CITY OF ALBUQUERQUE

RE: **700 Tijeras**
700 Tijeras Ave NW
Grading and Drainage Plan
Engineer's Stamp Date: 6/12/19
Hydrology File: K14D117

Based on the submittal received on 6/14/19, the Grading and Drainage Plan cannot be approved until the following corrections are made:

Sheet:
Grading and
Drainage Plan

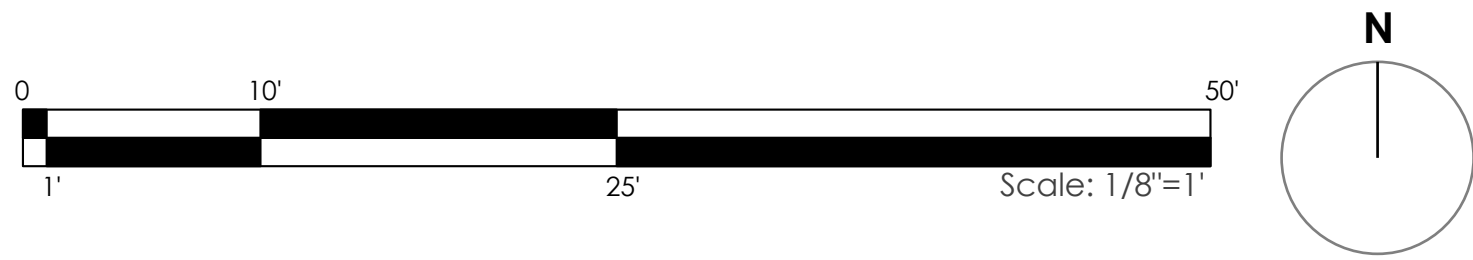
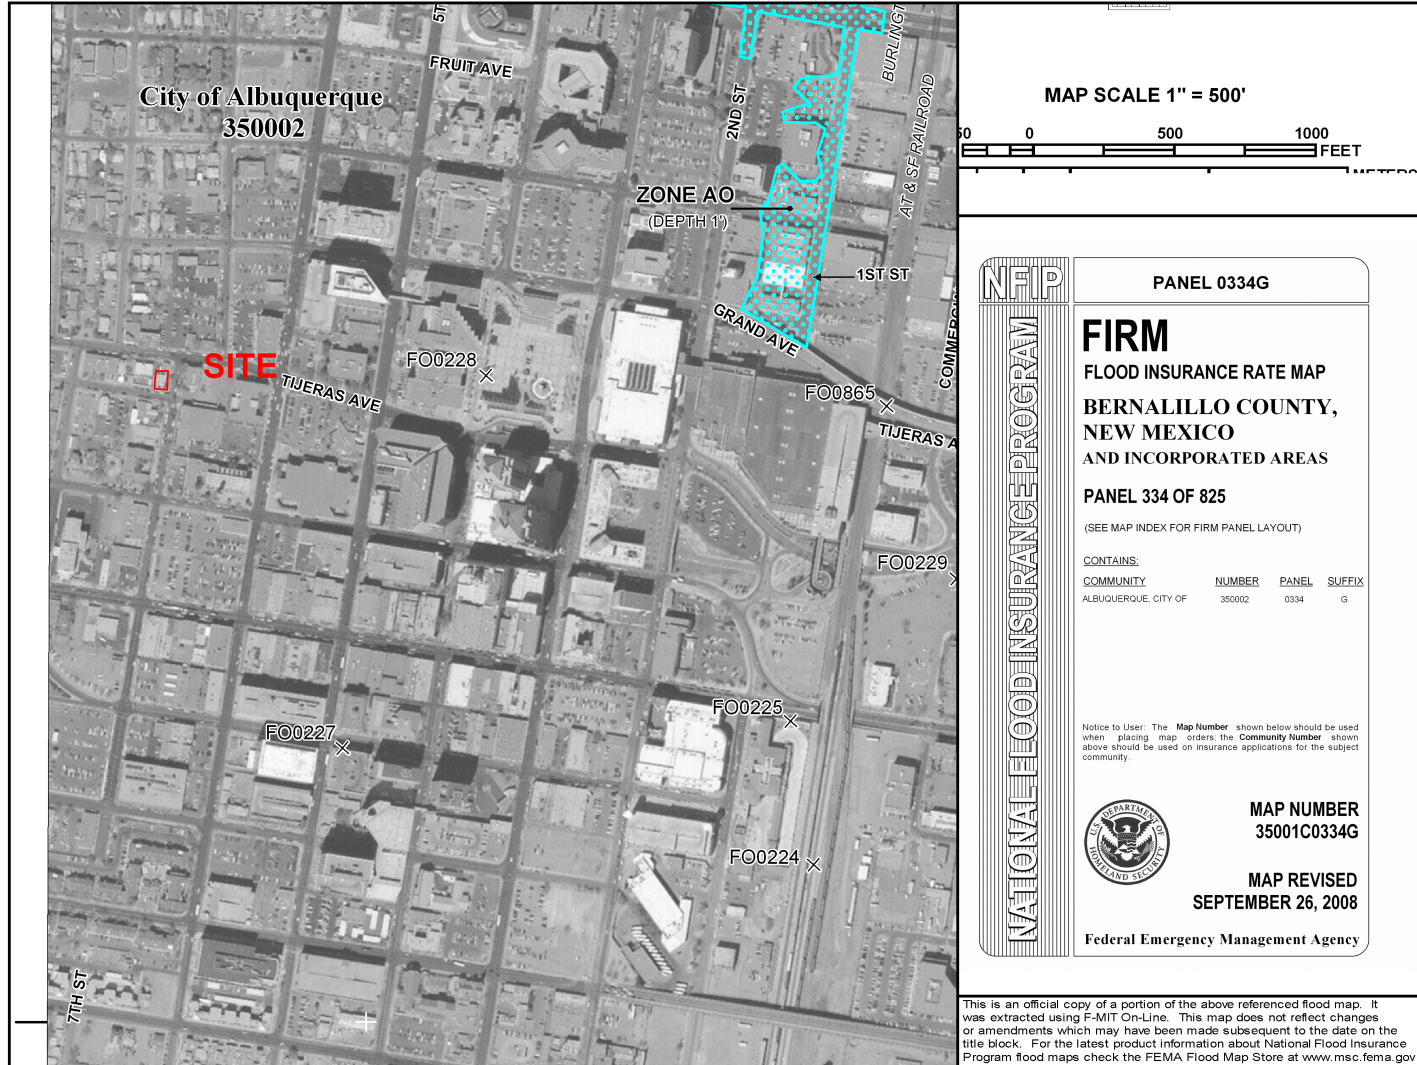
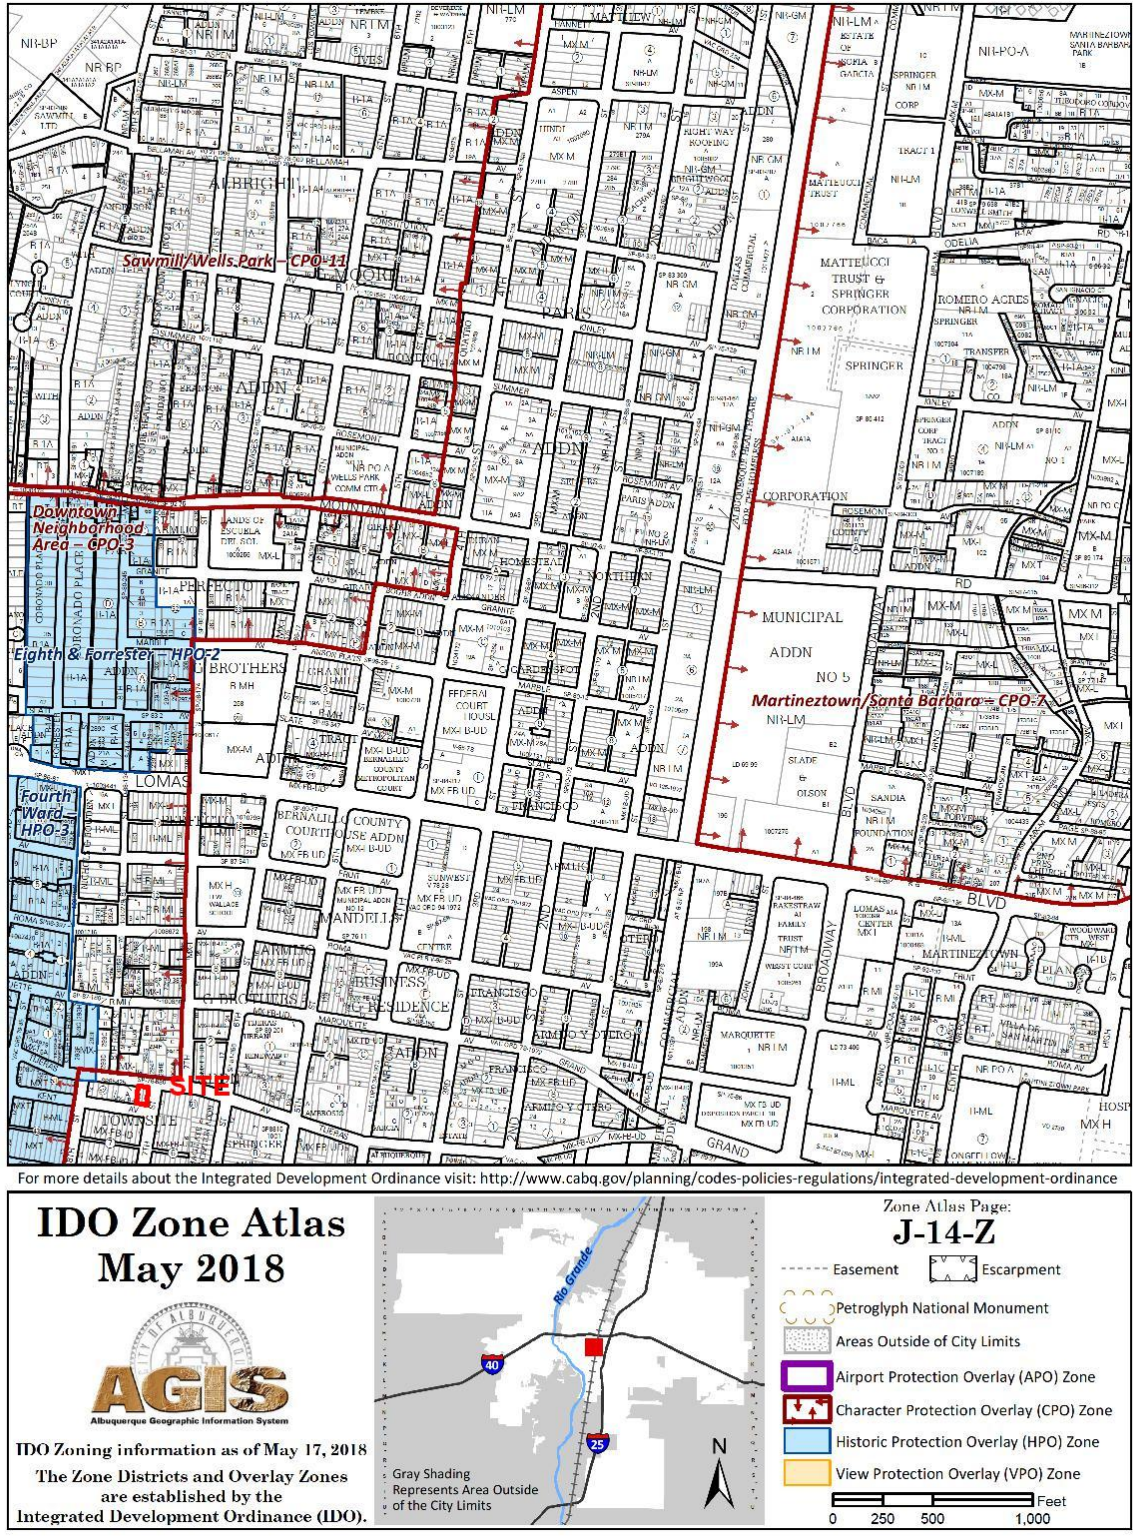
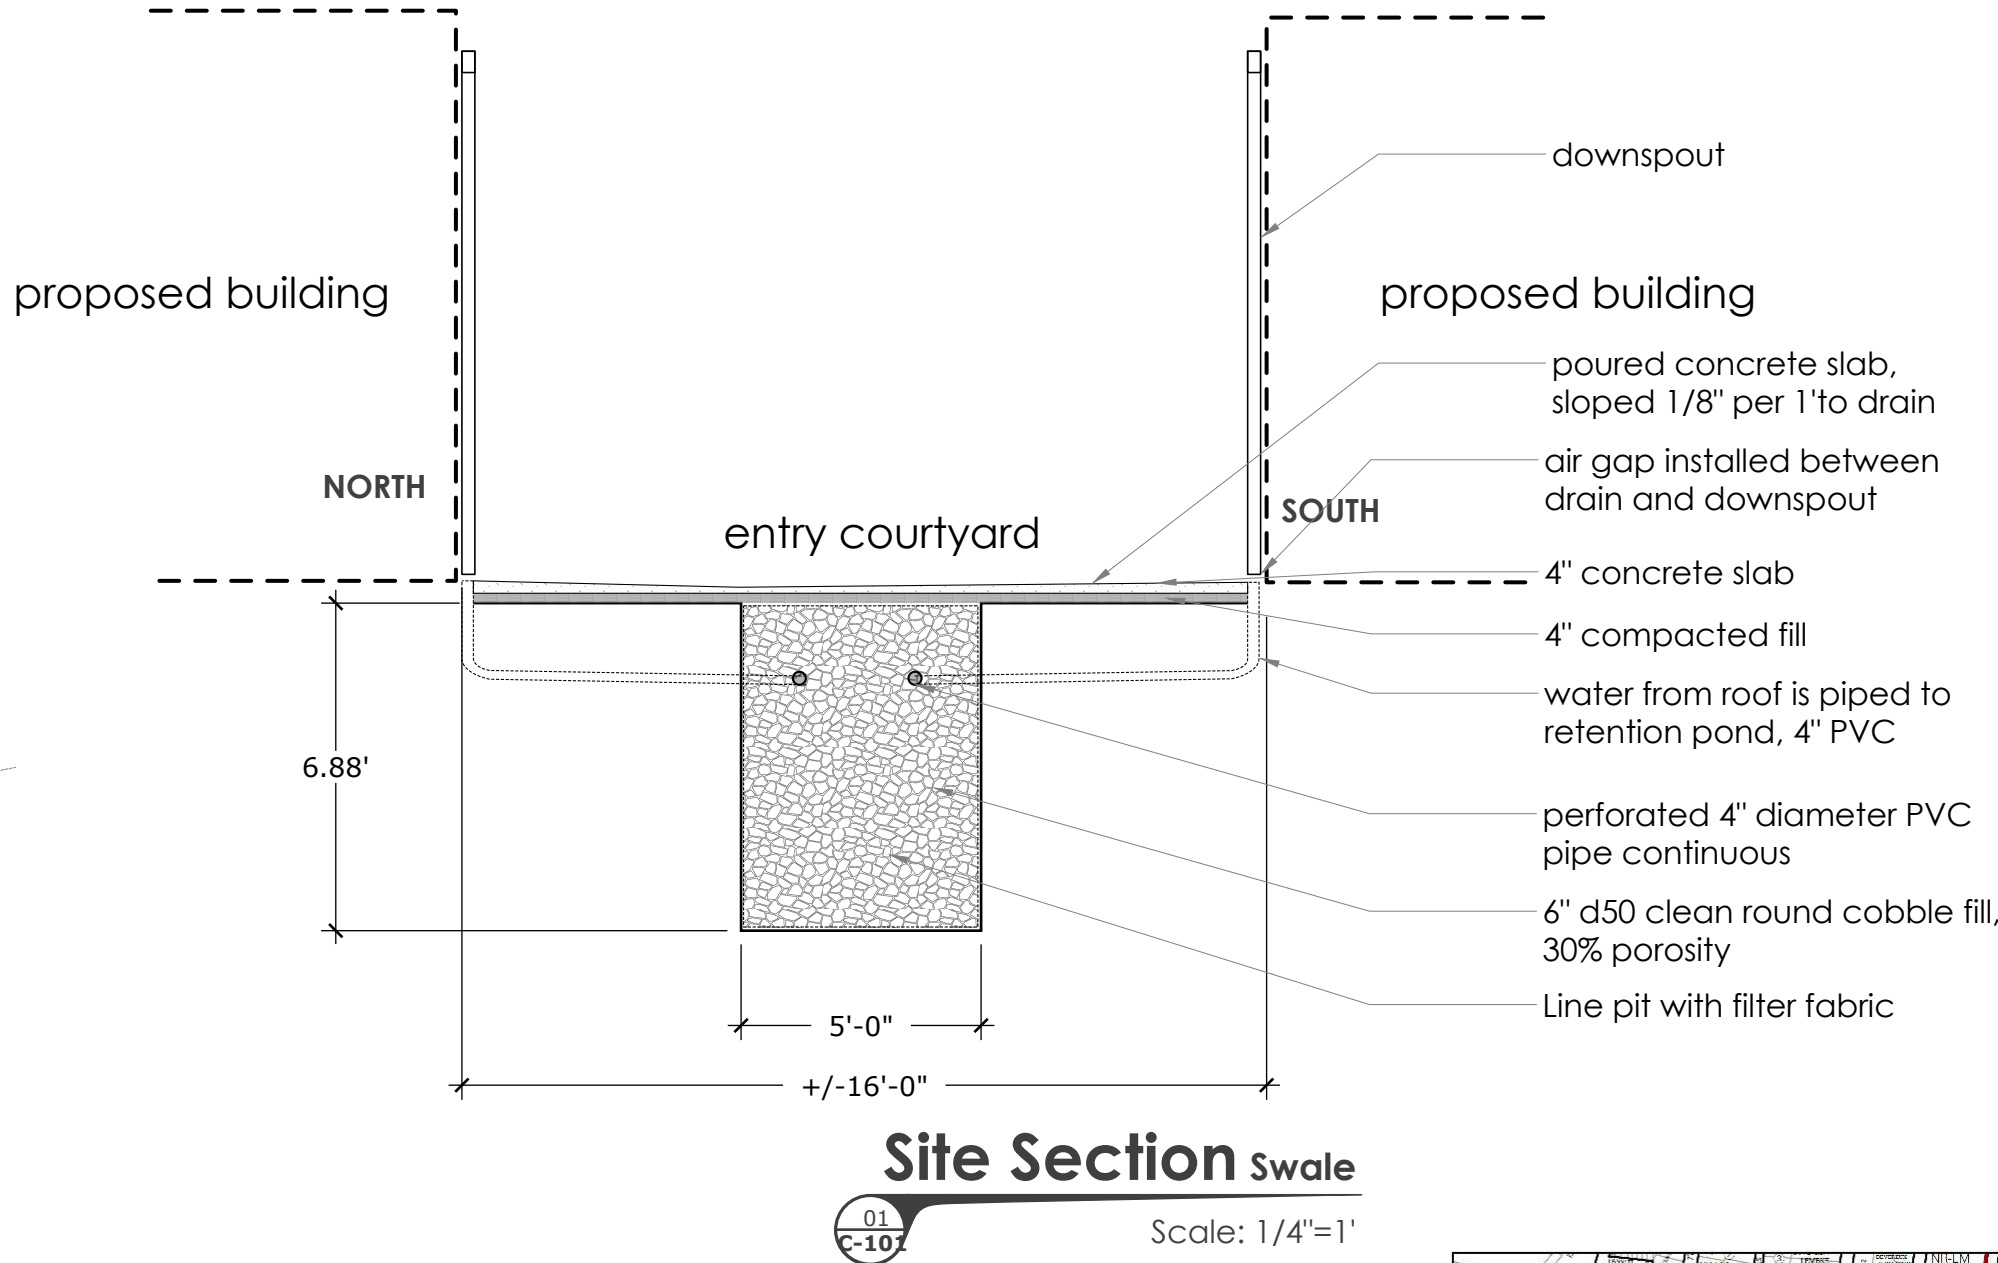
2. Include project benchmark and datum.
3. Provide existing site topography and label existing and proposed contours. Since the site is extremely flat, please provide spot elevations (existing and proposed) in enough density to verify the drainage areas and outfalls that you have indicated. Also include the finished floor elevation of the buildings.

5. Include the finished elevation for the courtyard slab and show how it will drain with slopes and spot elevations. It seems to drain to the middle, then east towards the trench drain, but this is unclear on the plan.

6. Remove the note that a Pad Certification will be required; Hydrology will just inspect at the time of C.O.
